MODIFICATION REQUEST:
Mixed Use Development
44-46 Walker Street, Rhodes
MP 10_0105 MOD 1

Director-General's
Environmental Assessment Report
Section 75W of the
Environmental Planning and Assessment Act 1979

September 2012

Drawing Name
Area Calculations - GFA

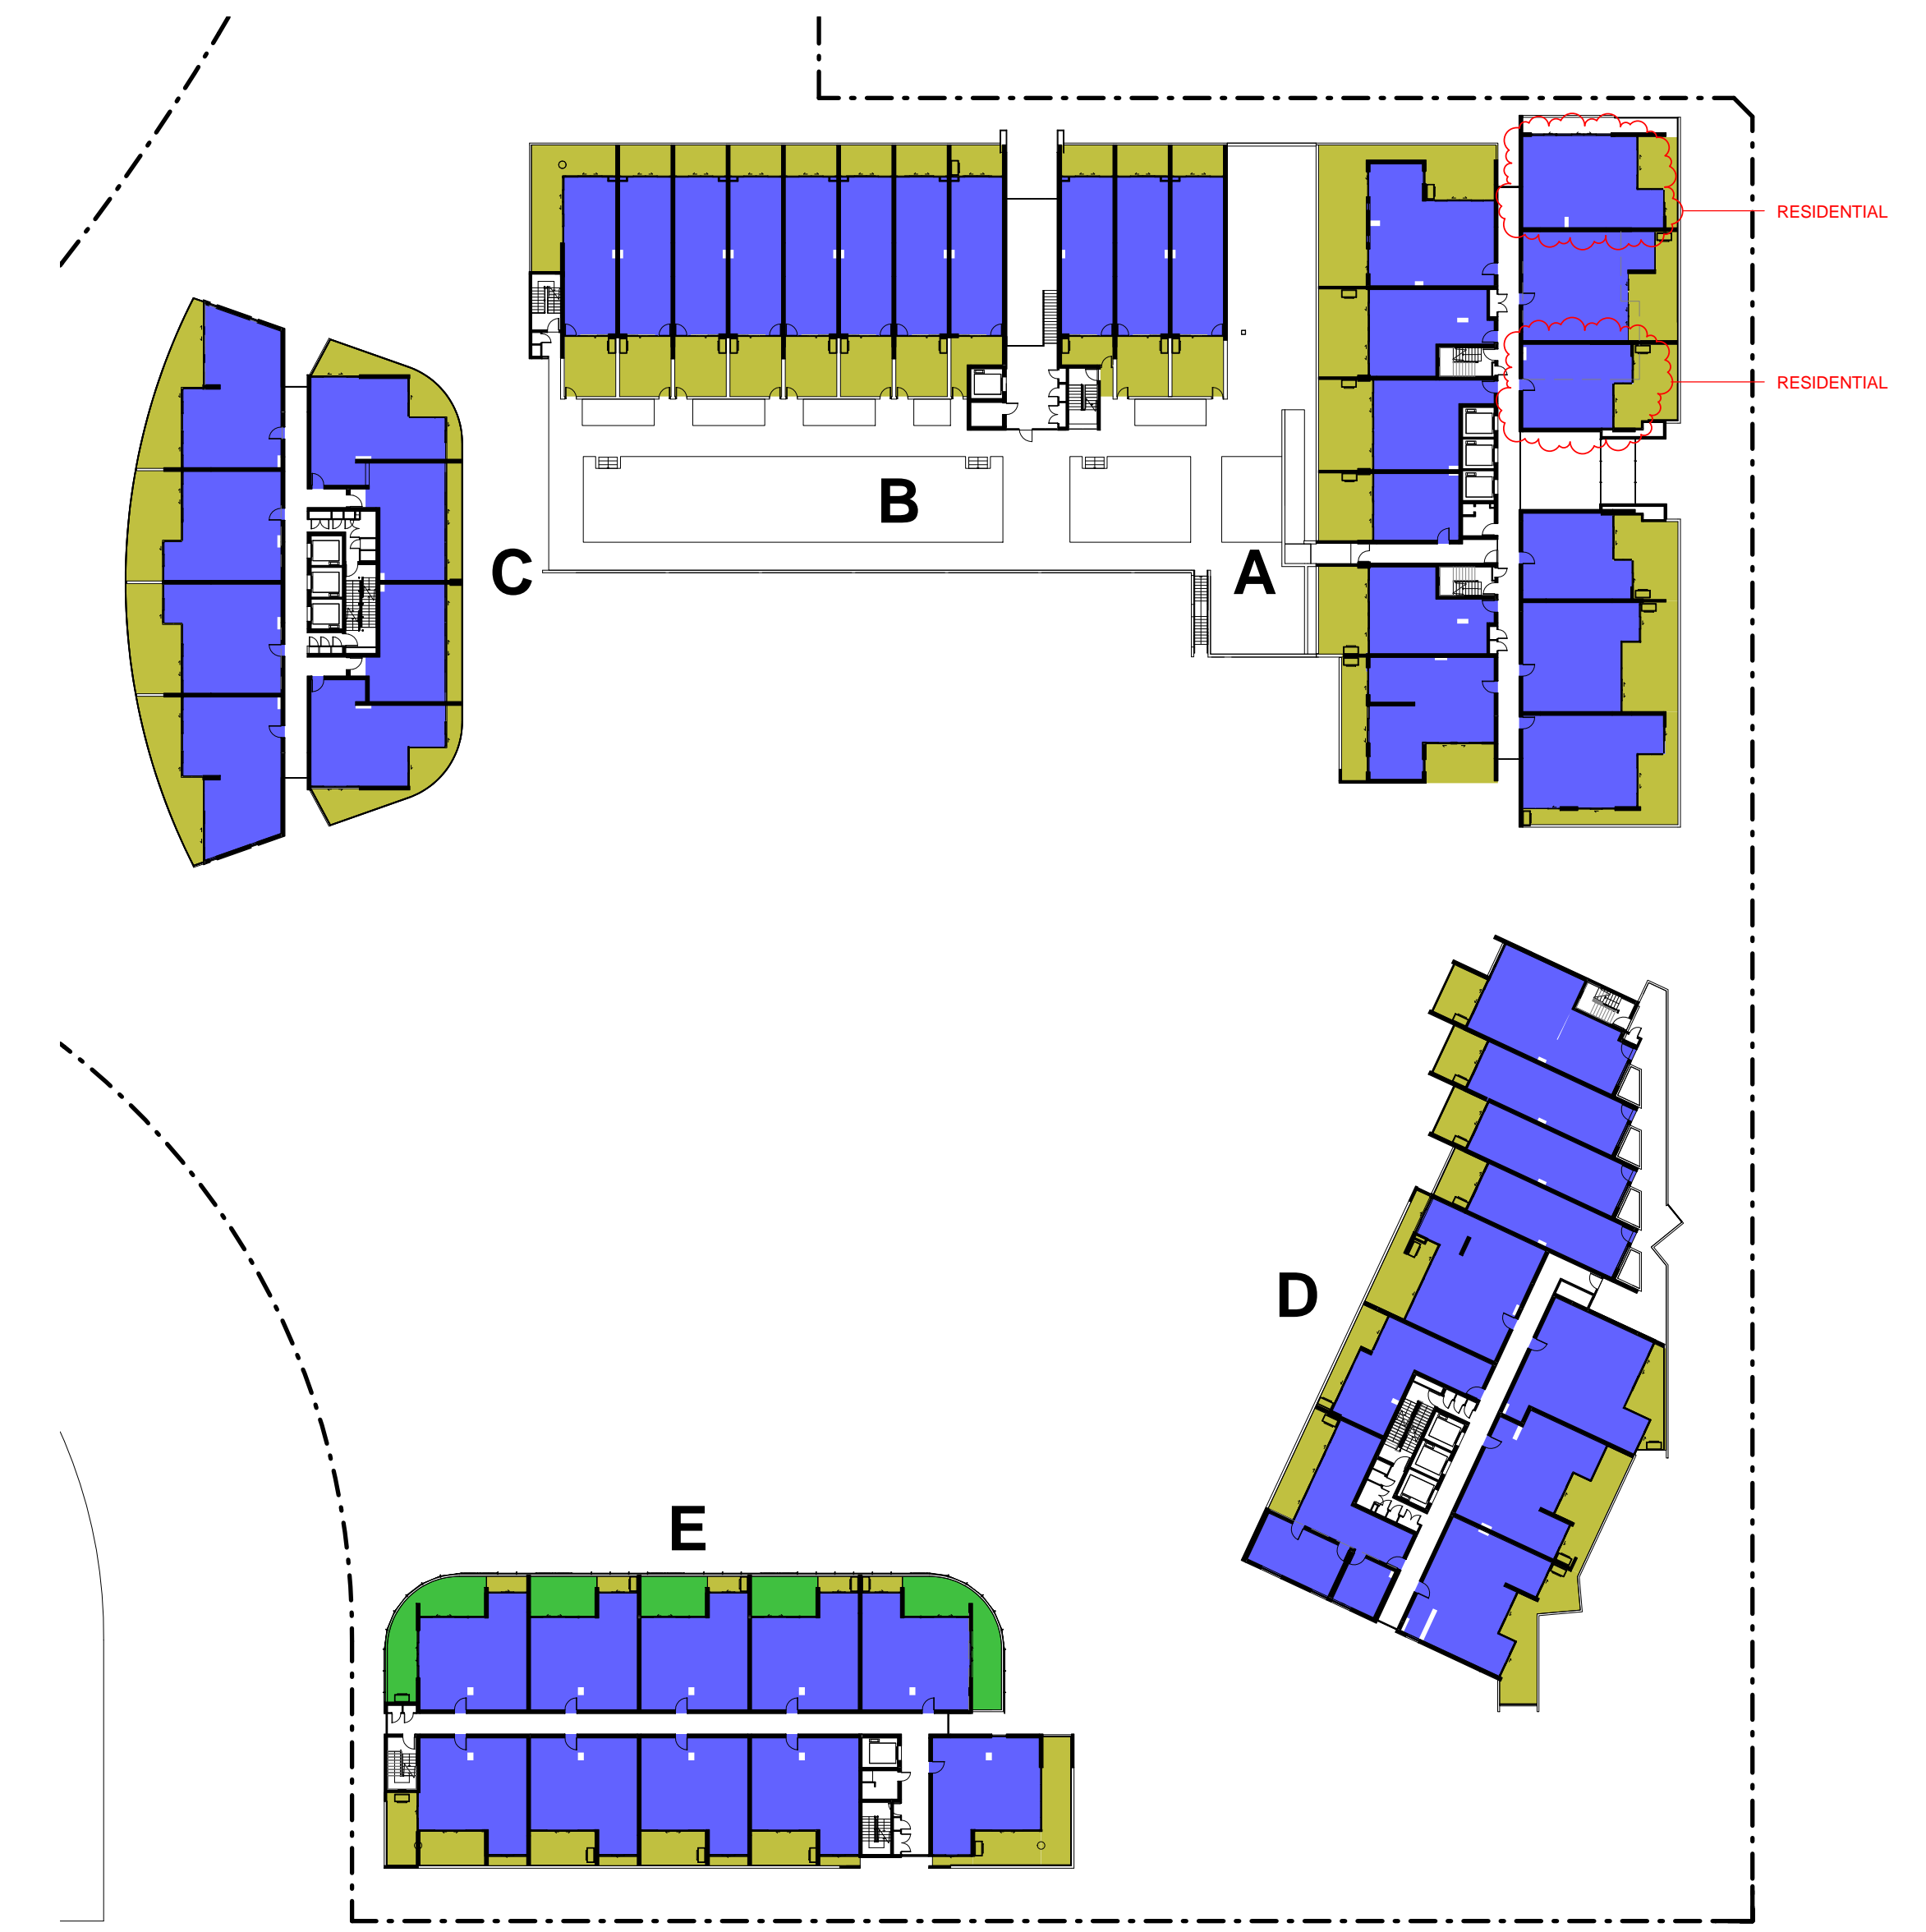
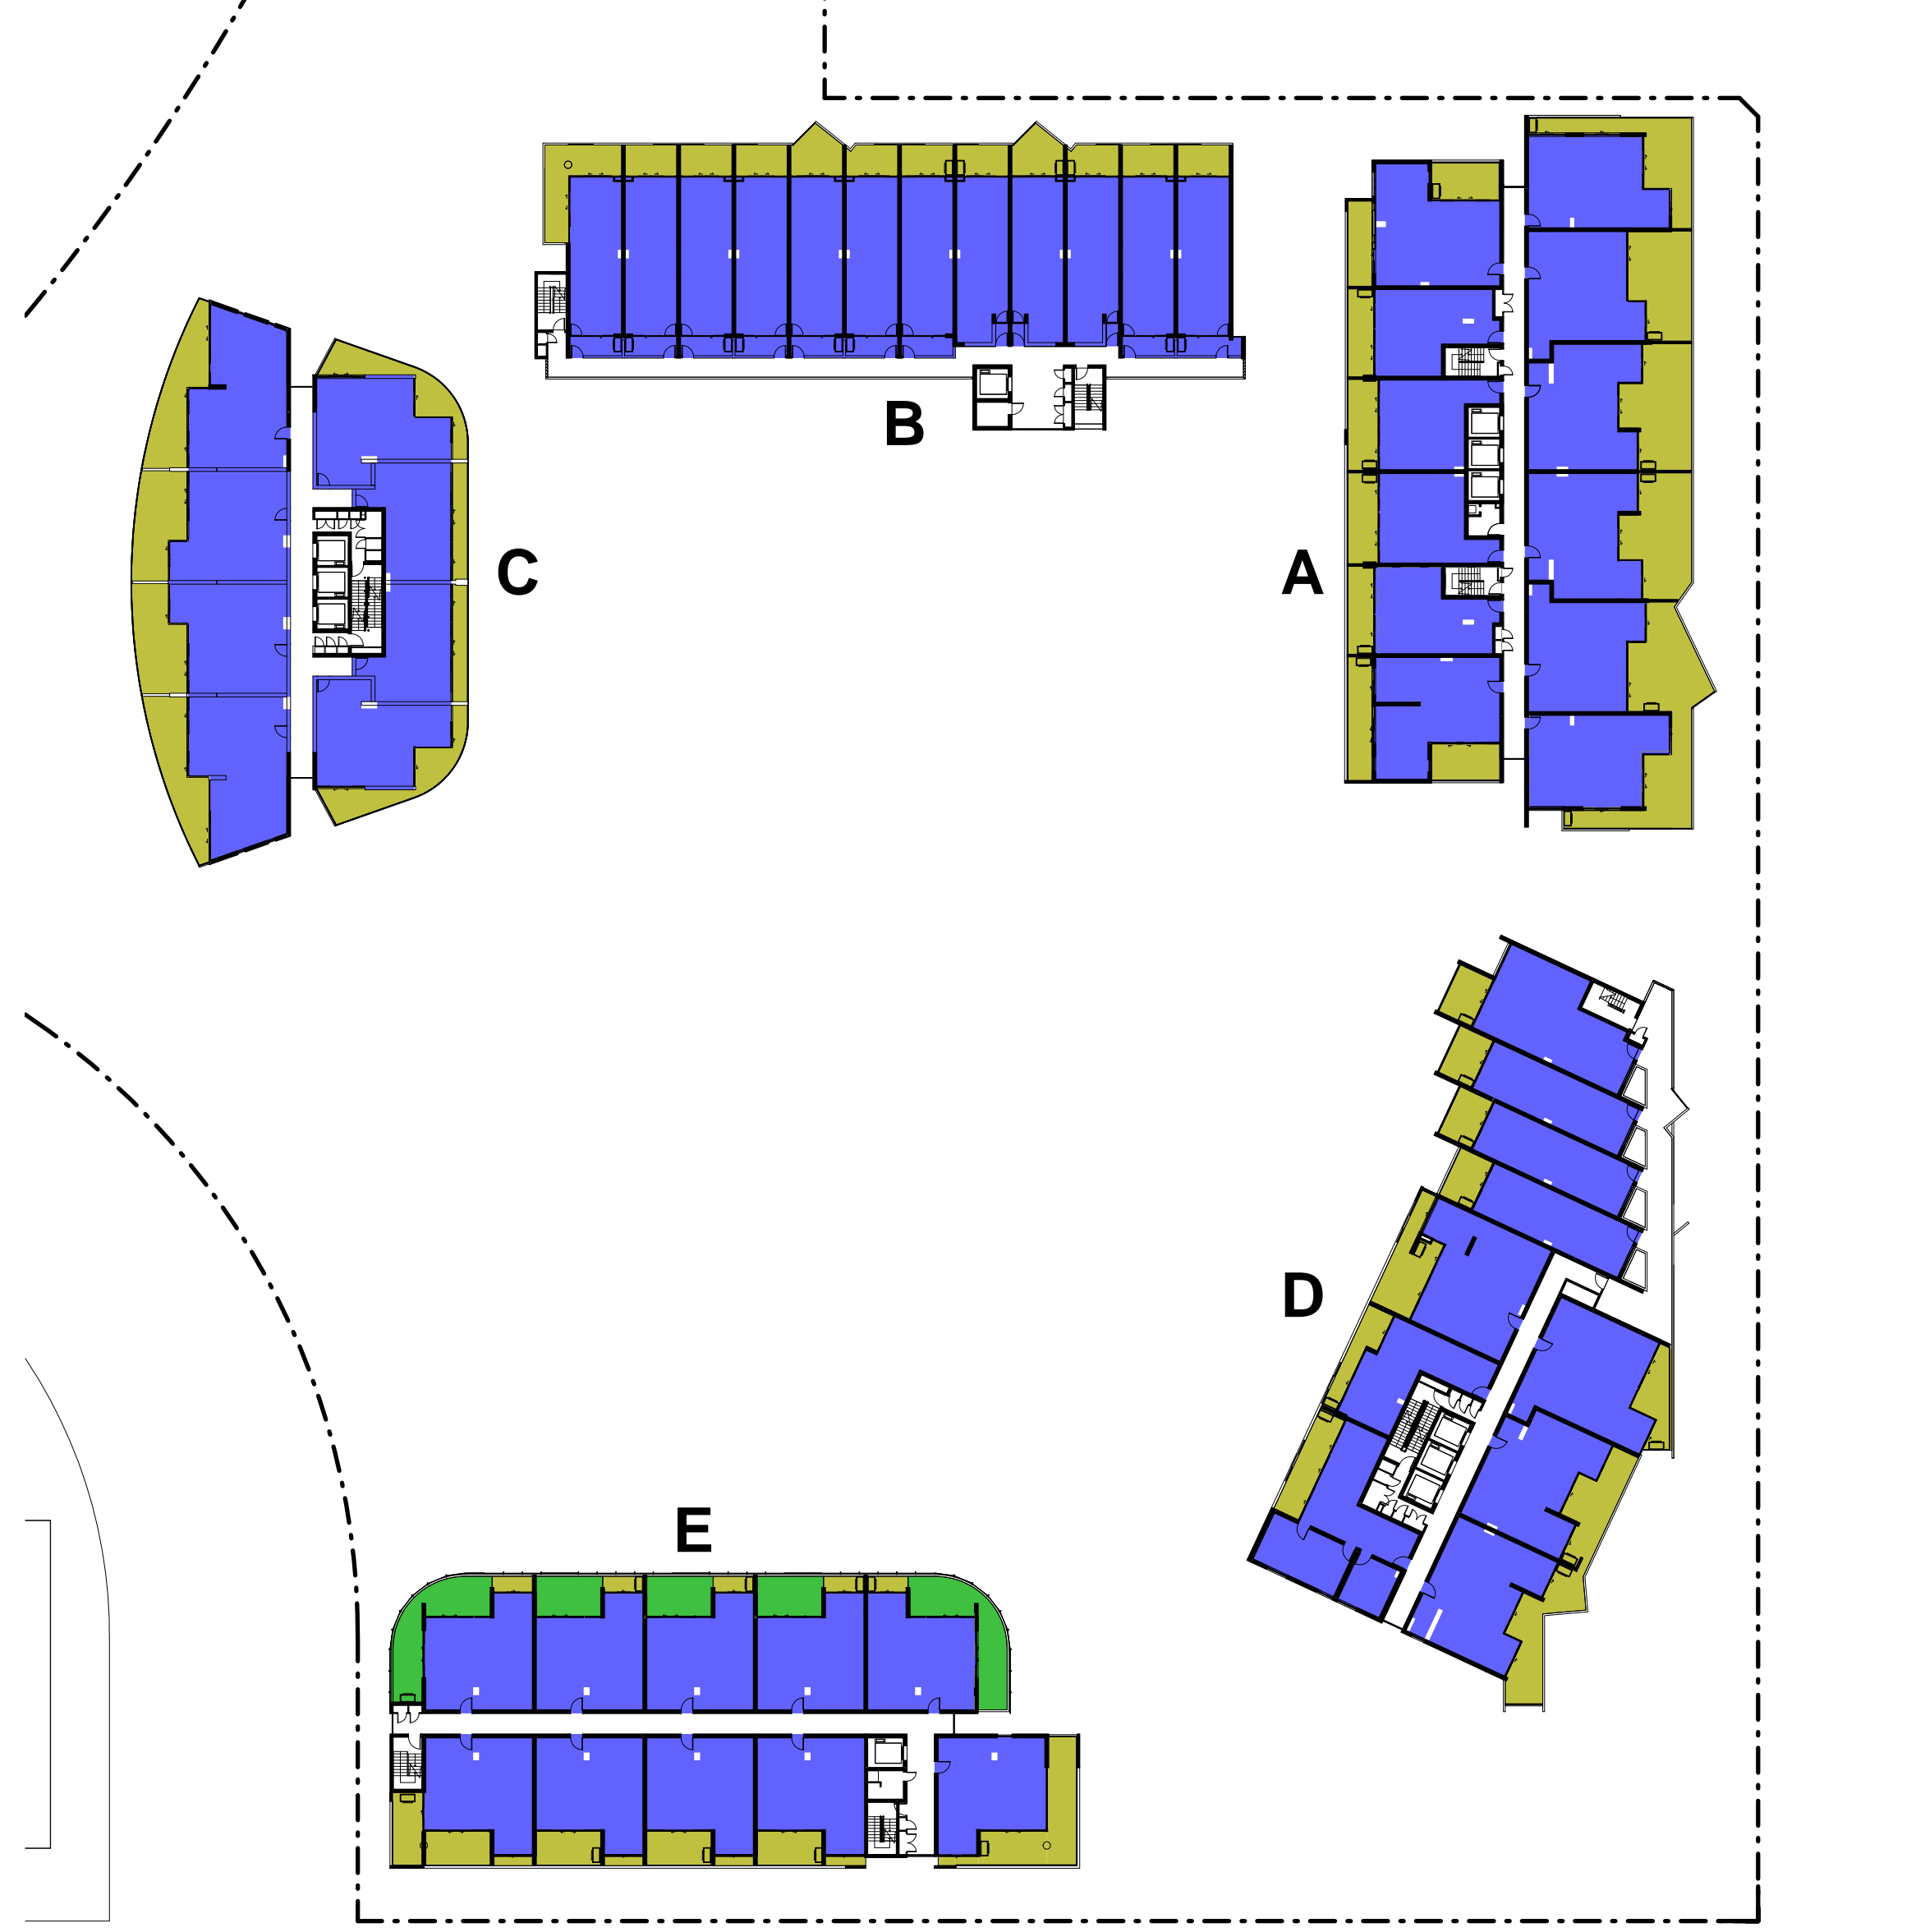
The proposed modification involves the conversion of two home offices and a common room approved for the podium level of Building A to be converted to retail tenancies. This will result in an additional 298m² of retail gross floor area (GFA) within Building A, bringing the total retail GFA of the site to 1,348m². **Figure 3** shows the location of existing retail at podium level (as part of Building D), and the location of proposed new retail tenancies at podium level within Building A.
